Northampton Gateway RFI: Comments on the draft Land Plans, Works Plans, Access and Rights of Way Plans and Illustrative Masterplan

These queries relate solely to matters raised by the drafting of the Works Plans and Land Plans and not the merits of the proposal. They are limited by the time available for consideration, and raised without prejudice to the acceptance or otherwise of the eventual application. They are provided to assist the preparation of the next iteration.

Drawing Title		WORKS PLANS KEY PLAN	
Scale	1:15,000	Drawn	P. Goodyear
Size	A1	Reviewed	S. Hilditch
Regulation	5(2) (j)	Document	2.2
Drawing Status		SUBMISSION	
Drawing No.		Revision	
NGW-BWB-LSI-XX-DR-C-00160		P12

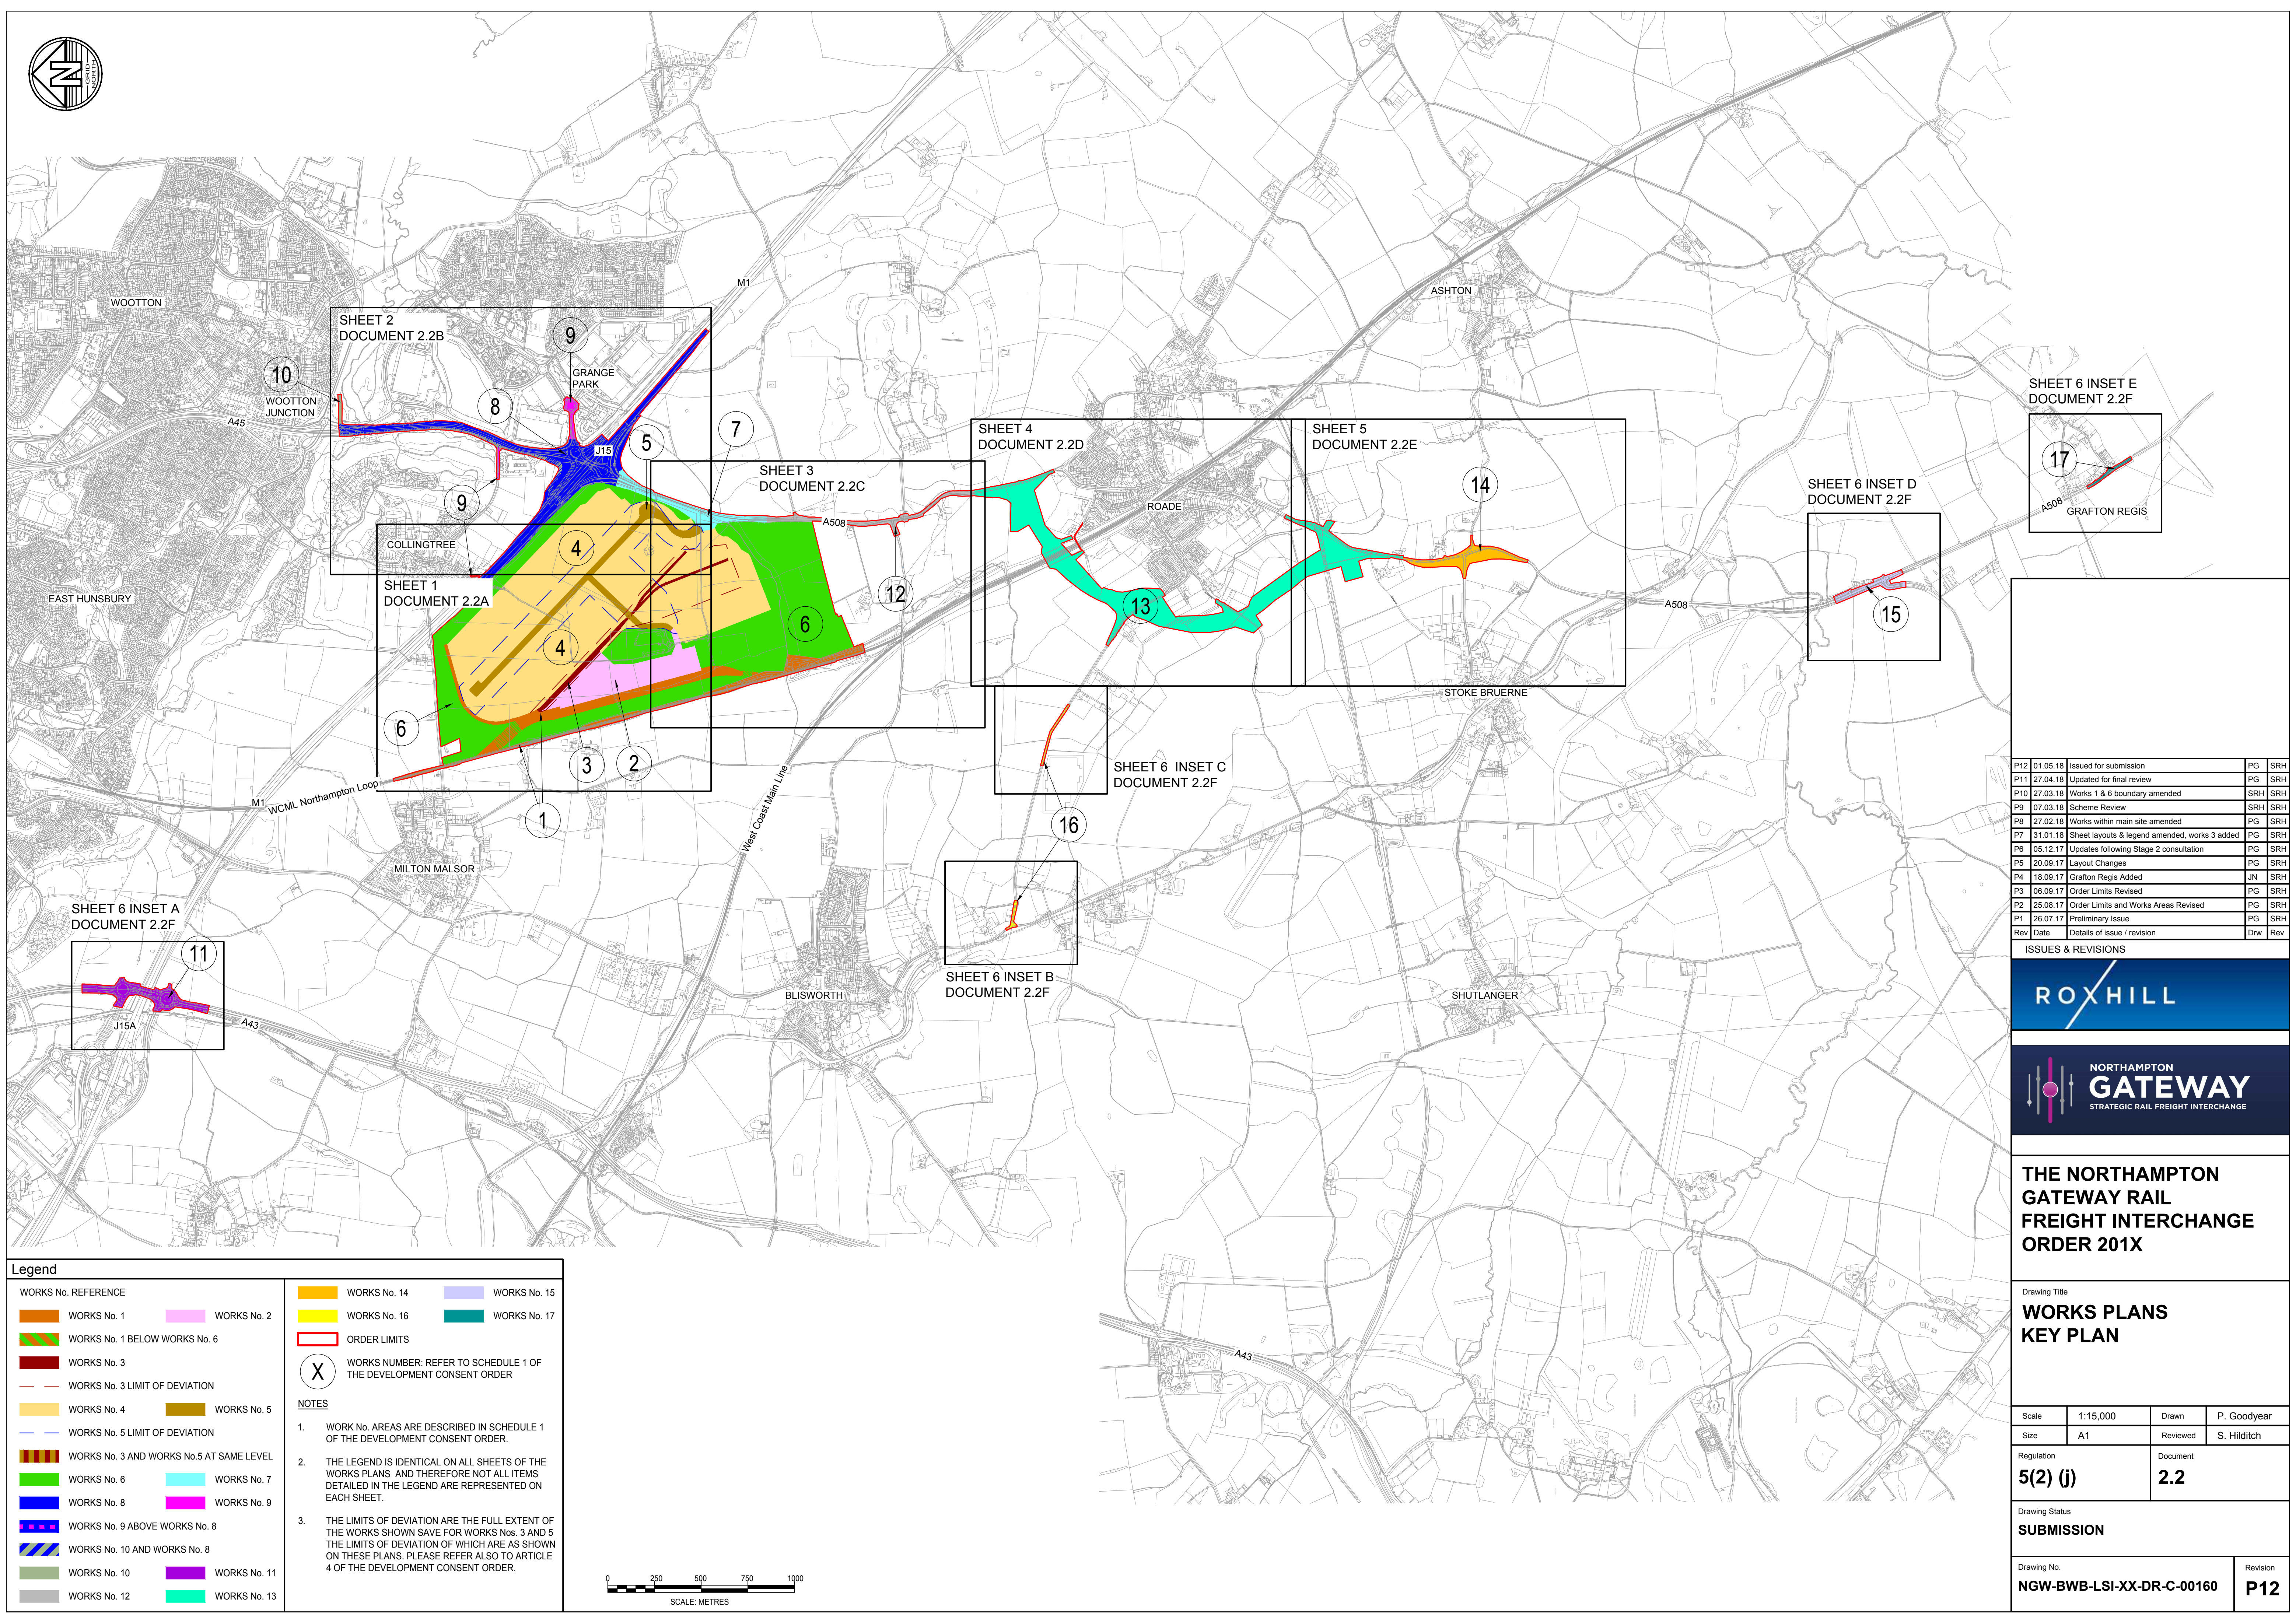
Q No.	location	Description of issue	Question/Comment
1.	General	Legend	The same Legend is reproduced across each sheet of the Works plans, resulting in some Works number references that are not relevant to a particular sheet.

2.	General	Limits of Deviation	<p>We note the Legend in relation to Limits of Deviation (LoD) including note 2. If 20 metres is included in the LoD on the plan, is that 20 metres in total or 20m either side (40m). Are the LoD included in the works as drawn on the plan?</p> <p>If so, consider the interrelationships between the plots. Ie works no 4 and 1. What is the effect of several works moving within these LoD?</p> <p>Consider adding the LoD as a separate layer to the works plans to provide a clearer definition of LoD proposed.</p>

3.	General	Lack of detail and size of proposed Works	<p>The detail of the proposed layout is not provided as a separate layer on the works plans. It would be helpful if the proposed layout was visible.</p> <p>Each separate work number could helpfully be broken down to give the reader a clearer understanding of the Works proposed especially in regards to phasing and understanding the individual aspects of each work.</p>
